Application Reference: 2025/0060**Site Address:** 9 Magnolia Close, Shafton, Barnsley, S72 8RF**Introduction:**

This application seeks full planning permission for a first floor side extension, and raising of roof to form loft conversion, to 2 storey detached dwelling.

Drawing Title
STREET SCENE

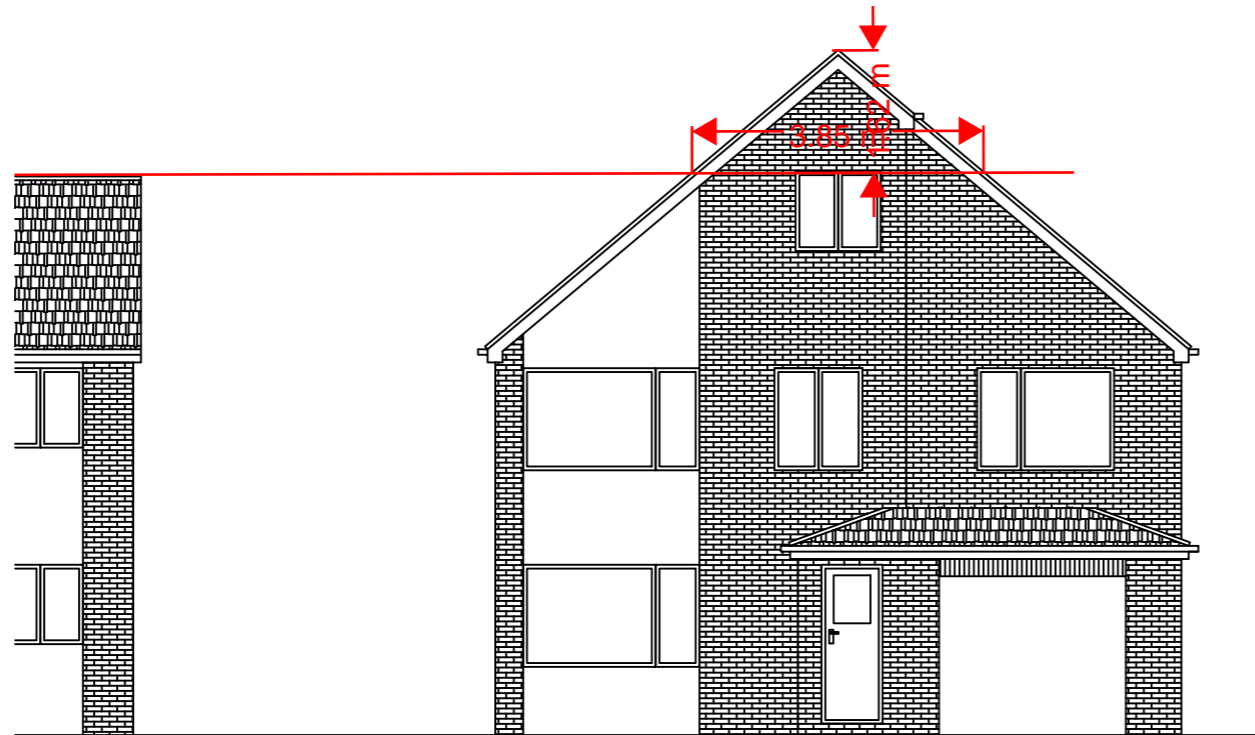
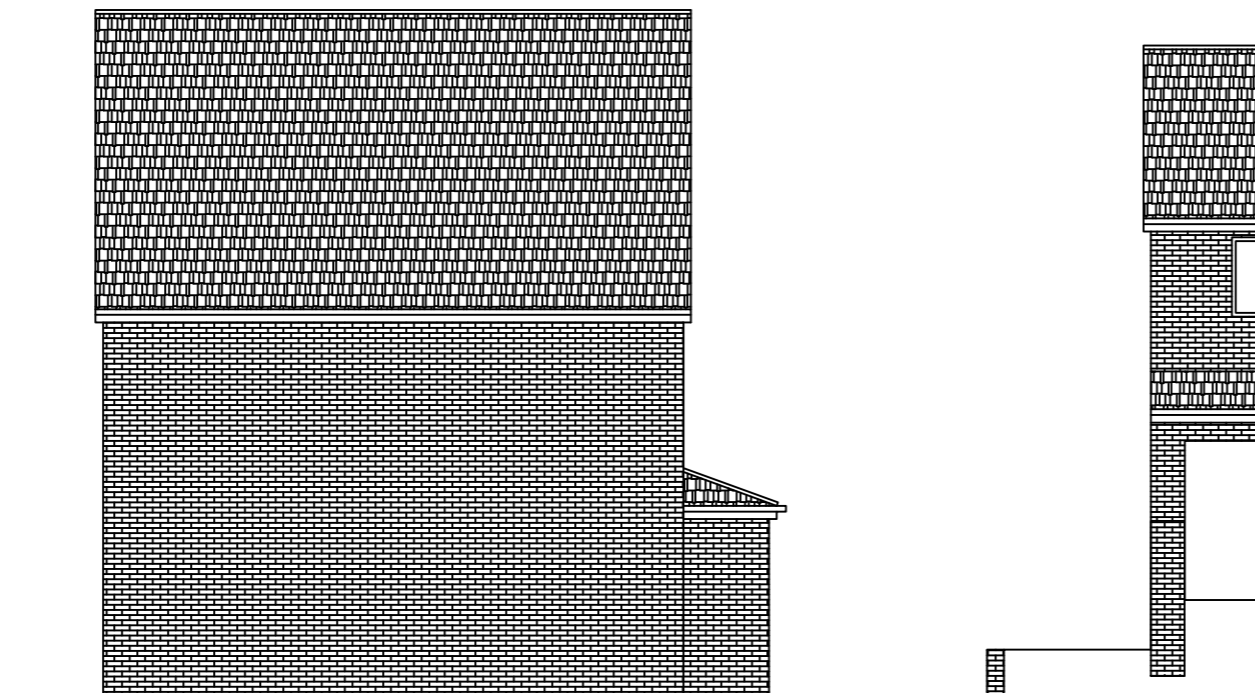
As the height of the dwelling would be a significant factor of the proposal, consideration must be given to the impact of the proposal within the broader area. Probably the most prominent view of the application dwelling would be from Park View at the junction of Magnolia Close. From this view, the incline of Magnolia Close is clearly visible with No.8, adjacent to the alleyway being the most prominent dwelling. The proposed changes to the application dwelling would broadly bring the dwelling in line with the height of No.8, so the impact would be minimal and not overtly out of character with the street scene. The dwellings to the rear of Magnolia Close on the western section of Park View are all set at a higher ground level. With some larger separation distances between dwellings on Park View, the application dwelling would be most visible between No.7 to No.11 and No.17 & No.19. For the latter, it would be the rear elevation, which is most prominent, whilst from No.7 to No.11, which also includes the alleyway, the western side elevation would be most prominent. For all these views, there will be a noticeable difference between what is visible now and what is proposed, but that difference is not expected to be obtrusive or out of character with the higher level houses on Park View or with the view of Magnolia Close as a whole, aided again by the height of No.8. It would therefore be considered that the impact within the broader street scene would be considered as modest.

It was necessary to make contact with the applicant to request further information about the proposed materials for use within the development. The applicant had already decided to revert to materials of a similar appearance with revised plans submitted. A proposed street scene plan was also requested to assist in assessment of the proposed roof height increase. Finally it was

Drawing Title
PROPOSED ELEVATIONS

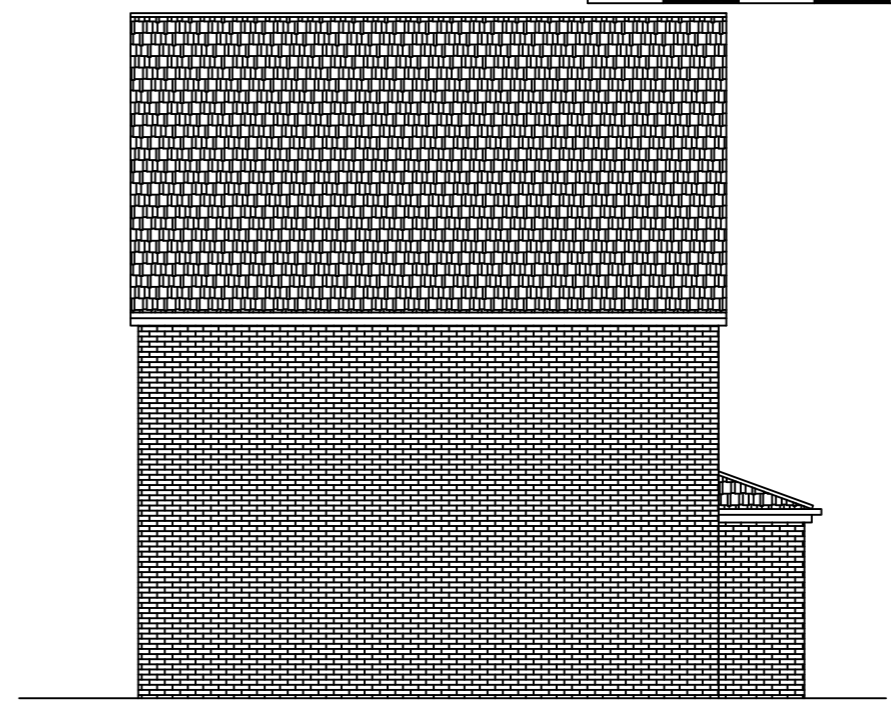
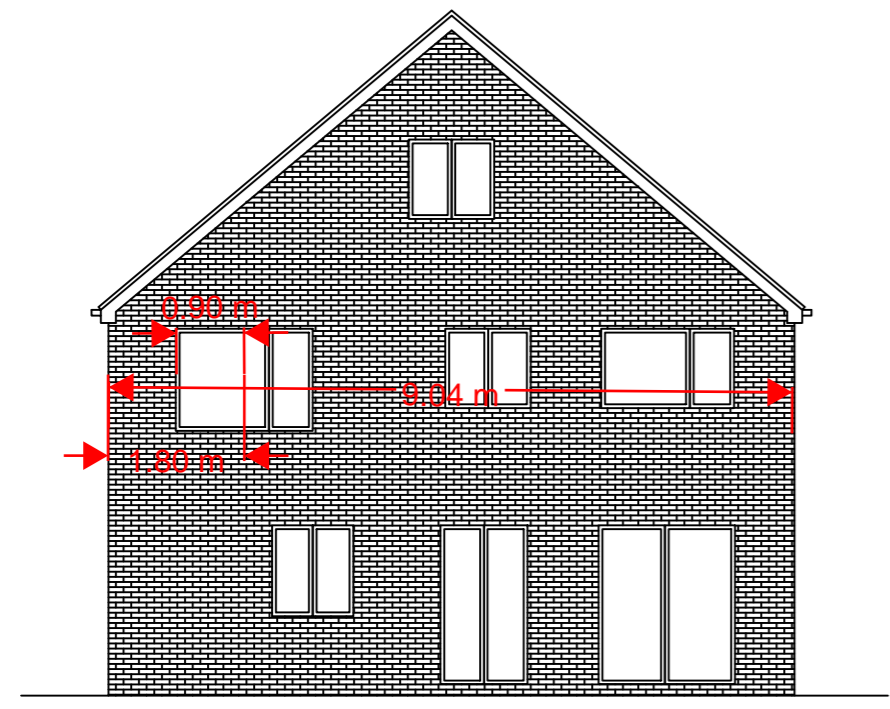
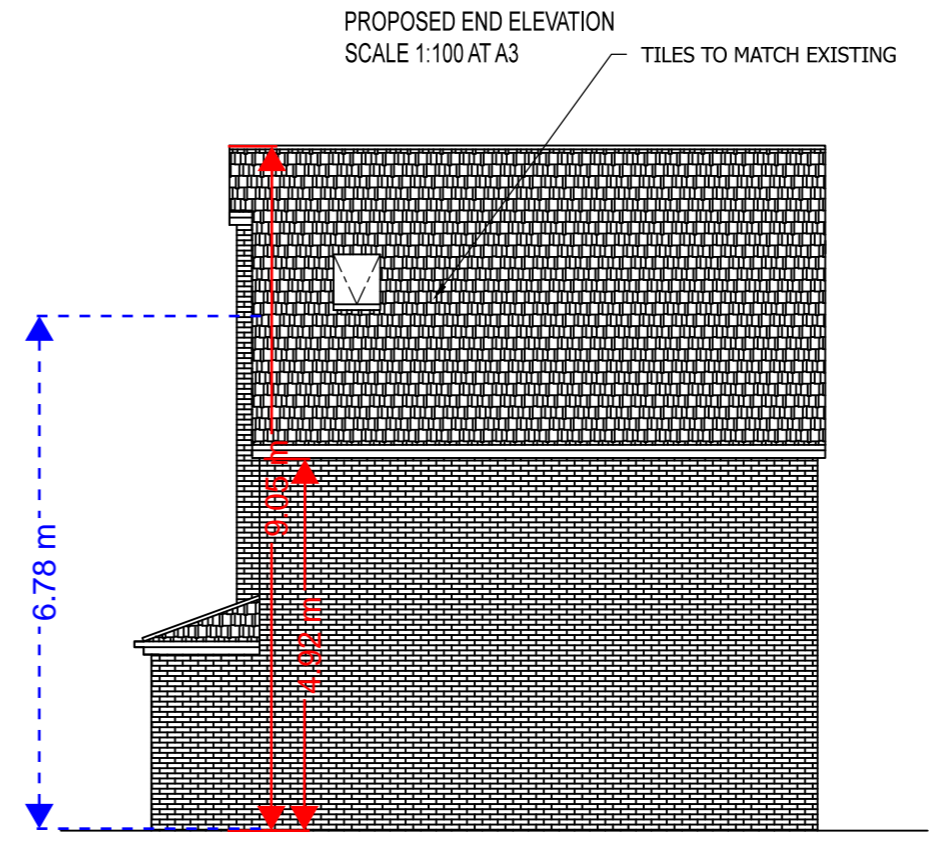
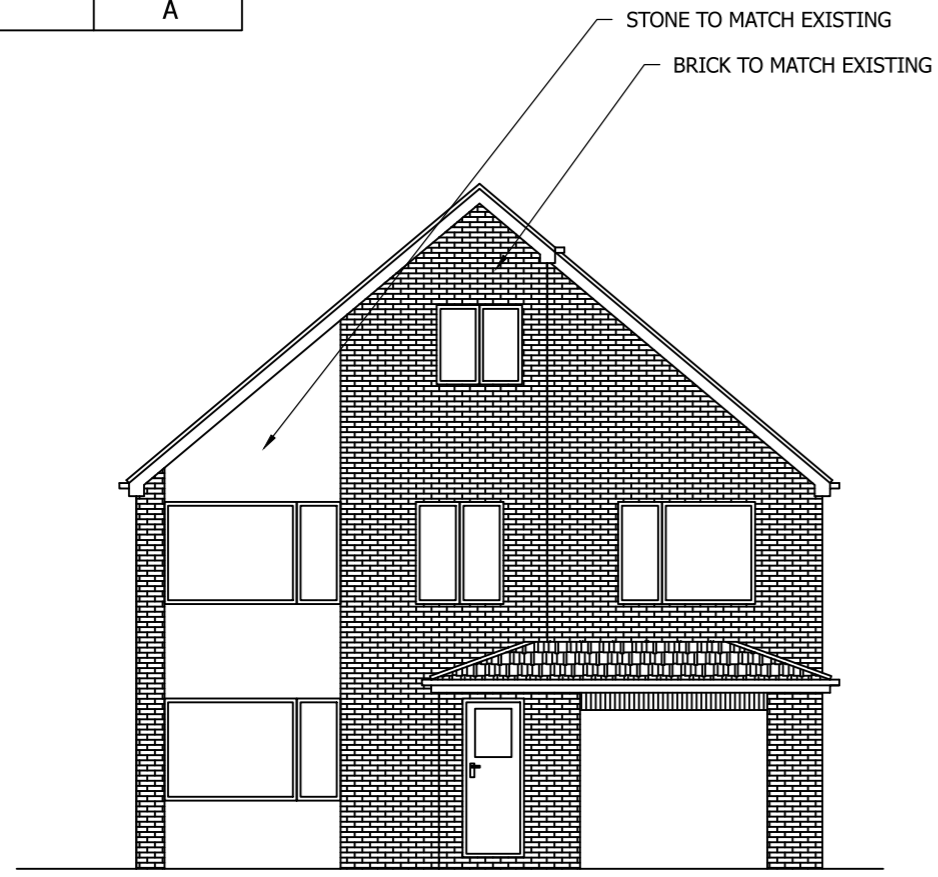
The proposal is to create in effect a 2.5 storey dwelling by building a first story extension on top of the existing attached ground floor garage, and the creation of a third floor of habitable accommodation within the roof space through raising the height, and extension (or replacement) of the main roof over the first-storey garage extension, creating a unified roof. The footprint of the first and effective second floors would have external measurements of approximately 26sqm each. The width of the proposal would match that of the garage at approximately 3.62m but the approximate length of 7.37m on both floors above would be approximately 1.44m shorter than the ground floor garage including an approximate 31 cm set

back from the original dwelling's front elevation. The proposed new eaves height for the combined dwelling would remain unchanged at 4.92m, but the ridge height increases by approximately 2.83m from 6.78m to 9.05m. For comparison, the original garage has an eaves and ridge height of 2.32m and 3.94m respectively. As part of the current garage extends beyond the original front elevation of the dwelling, the eaves and ridge heights would remain on the ground floor aspect of the garage, appearing as a front canopy, extending approximately 1.48m from the proposed two-storey extension and 1.17m from the dwelling's original front elevation. All measurements were taken on the west elevation of the submitted elevations plans.

The House Extension and Other Domestic Extensions SPD requires that minimum distances are maintained between directly facing windows or windows facing a blank elevation. In this proposal four windows would require assessment. For all windows, measurements are approximate and taken from the centre of the window indicated on the plans. Starting with the front elevation of the proposal, the first storey window of the two-storey extension would only overlook Magnolia Close and front gardens, not directly into any other window, with a straight line hitting the corner wall of No.4 at distance 28m. The second storey window may directly overlook a window of No.4 but again at a distance of 28m. Both front windows would meet the minimum separation distance of 21m for facing windows within a first story extension or those within a roof space, as the second storey window is. For the front elevation windows, there would be little or no impact on neighbour amenity.

For the rear windows, additional SPD Guidance arises as a 10m distance should be maintained between two (or more) story extensions and the rear boundary treatment. Starting with the proposed first storey window within the extension, the window would only have a distance to the rear boundary of 6m although a straight-line distance of 26m to the side elevation to No. 17 Park View is maintained. From the second story window, a larger 8.74m distance is achieved to the rear boundary, and 28m to rear elevation of No.17 Park View is maintained. Whilst both windows meet the minimum standards in relation to distance between windows or a blank elevation, both fail on distance to the rear boundary. In mitigation, an obscured glazed, first-

storey window has been agreed, to protect the amenity of neighbouring gardens to the rear of the application dwelling. For the second storey window, with a larger distance to the rear boundary, the distance being closer to the required 10m, and with a smaller window size, essentially located within the original, although extended aspect of the original house, discretion has been used to allow this window not to have obscured glazing as the impact on neighbouring amenity would not be considered sufficiently detrimental to refuse the window or overall proposal, especially with no neighbour representations being received. For reference, if the window had been located wholly within the fabric of the existing dwelling, it would have been allowed through Permitted Development legislation. With the proposed first storey window featuring obscured glazing, the impact would be considered to have little or no impact on neighbouring amenity. However, the second storey window within the proposed new roof of the existing dwelling would be considered to have a modest impact on residential amenity.

agreed that a condition for obscured glazing on the first floor, rear elevation window within proposed extension was required to protect amenity of residential dwellings to the rear of the application dwelling.
